Ribble Valley Borough Council  
Housing & Development Control

Application no: **3/2021/0573**

Address: **38 Mitton Road Whalley BB7 9RX**

Proposal: **Proposed two storey rear extension and detached garage.**

6254 - P01	REV -
------------	----------

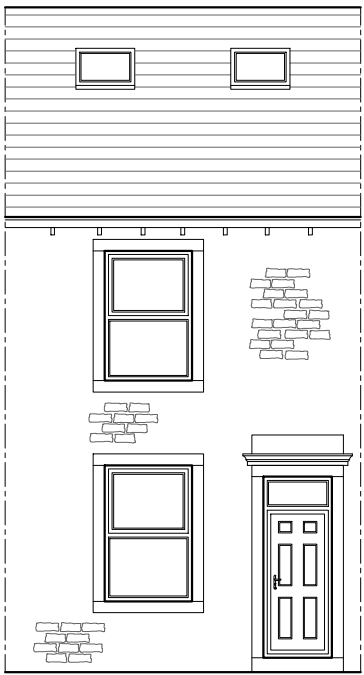
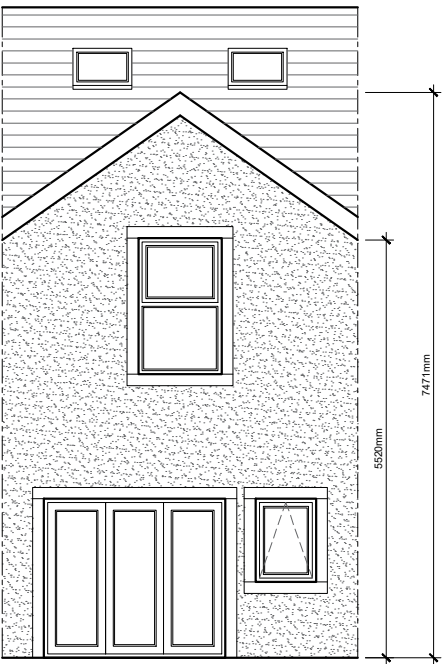
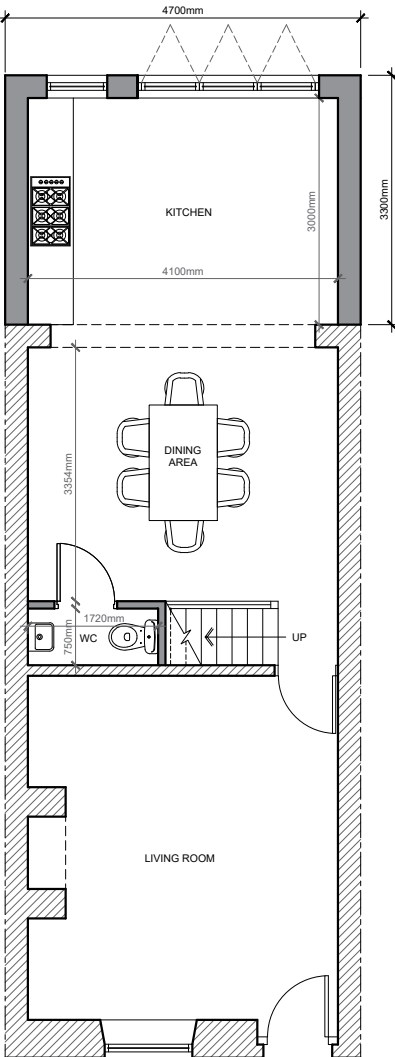
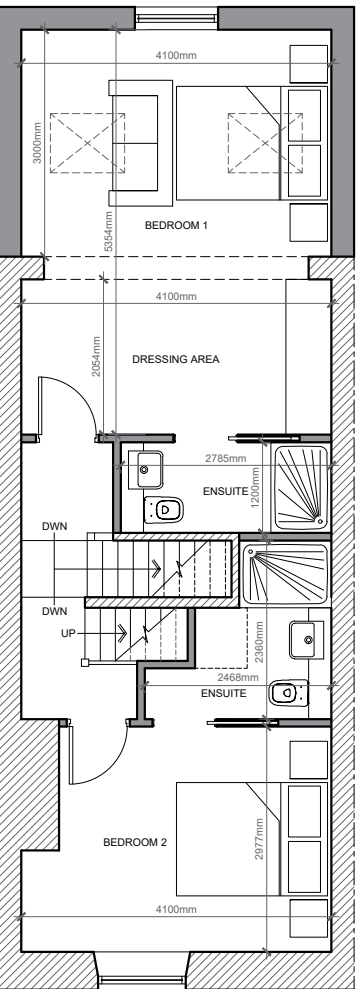
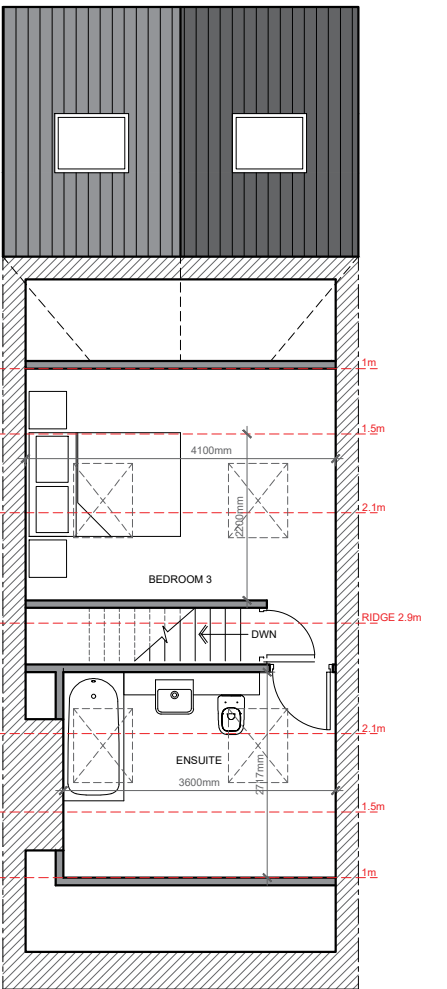
To comply with the LHAs guidance contained in the Joint Lancashire Structure Plan, the site is required to provide 2 car parking spaces. These will be provided by the detached double garage which has the internal useable dimensions of 5.65m x 5.85m, as detailed on SPA drawing number 6254-P01 titled "Proposed Plans and Elevations."

While the double garage does not meet the LHAs guidance when providing two car parking spaces, with the LHA requiring the internal useable dimensions of the garage to be 6m x 6m, the LHA are aware that the site has a gravel area fronting the proposed garage. Therefore if the Applicant is unable to park 2 cars in the double garage, they are likely to park one of the vehicles on the gravel area which is accessed from a private, unadopted track a significant distance away from the public highway. As a result, the LHA have no objection to the proposal.
